Application for Planning Permission for Works or Extension to a Dwelling

Development: Rear extension
Location: 3 Wells Crescent Aldwick PO21 3RP

Location Block Plan (Extract from Ordnance Survey)

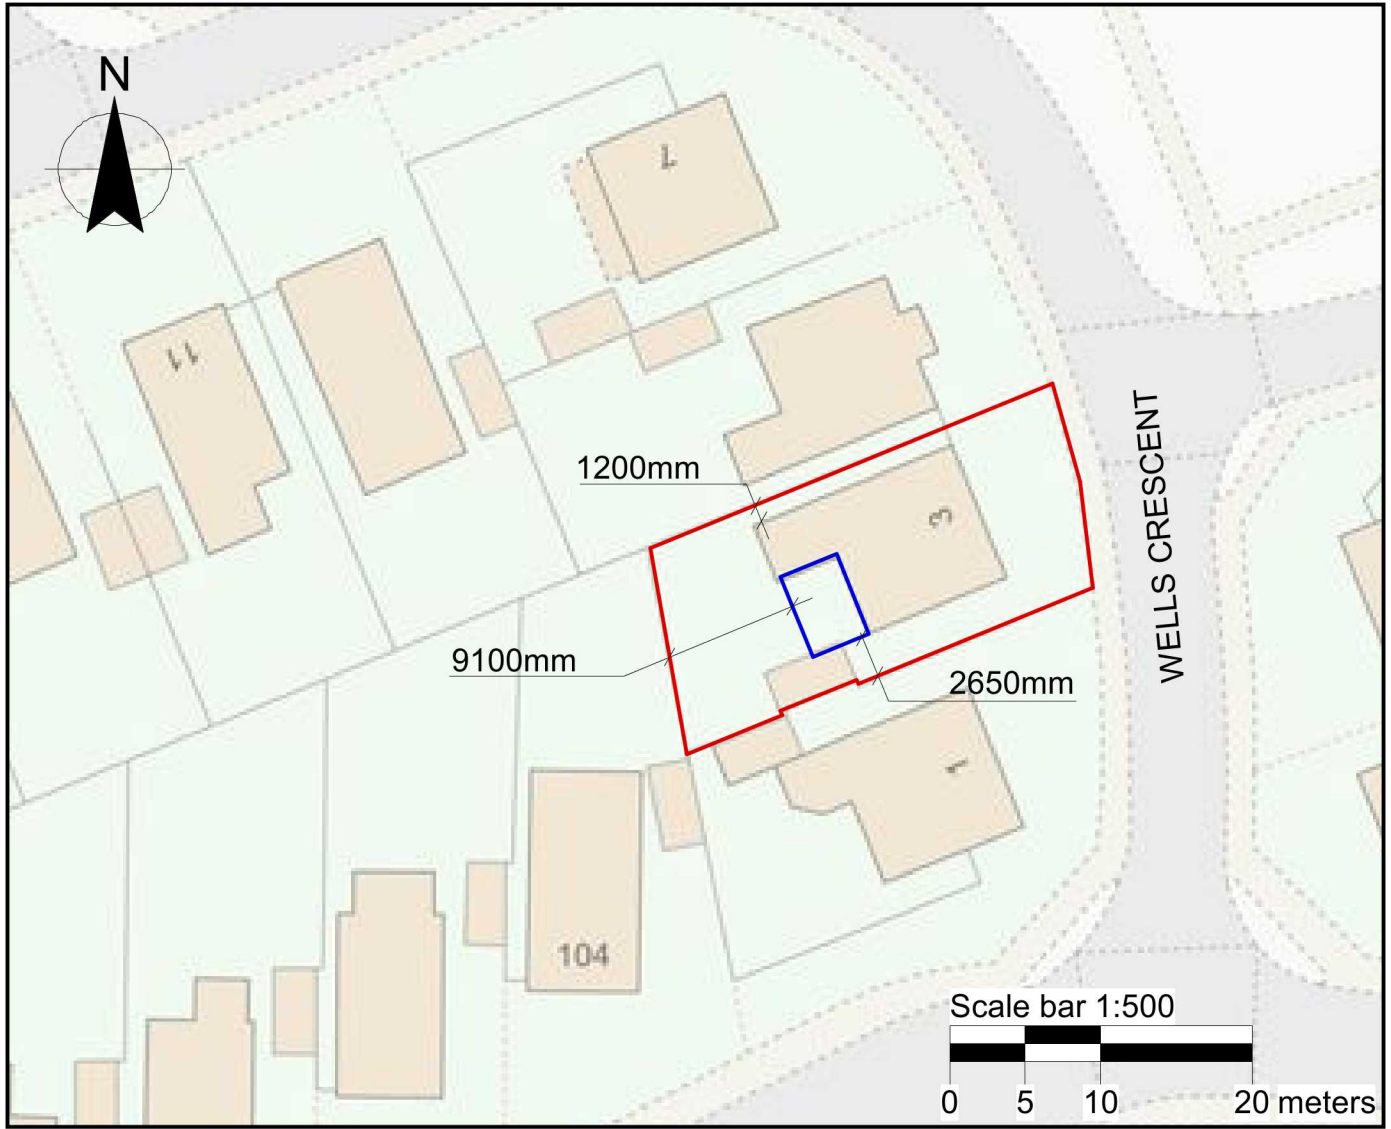
Location & Block Plan

You are required to have a scale bar on all your plans. These are missing on your location and block plans. Please amend.

Block Plan

You are required to have dimensions from the proposed extension(s) to all site boundaries.
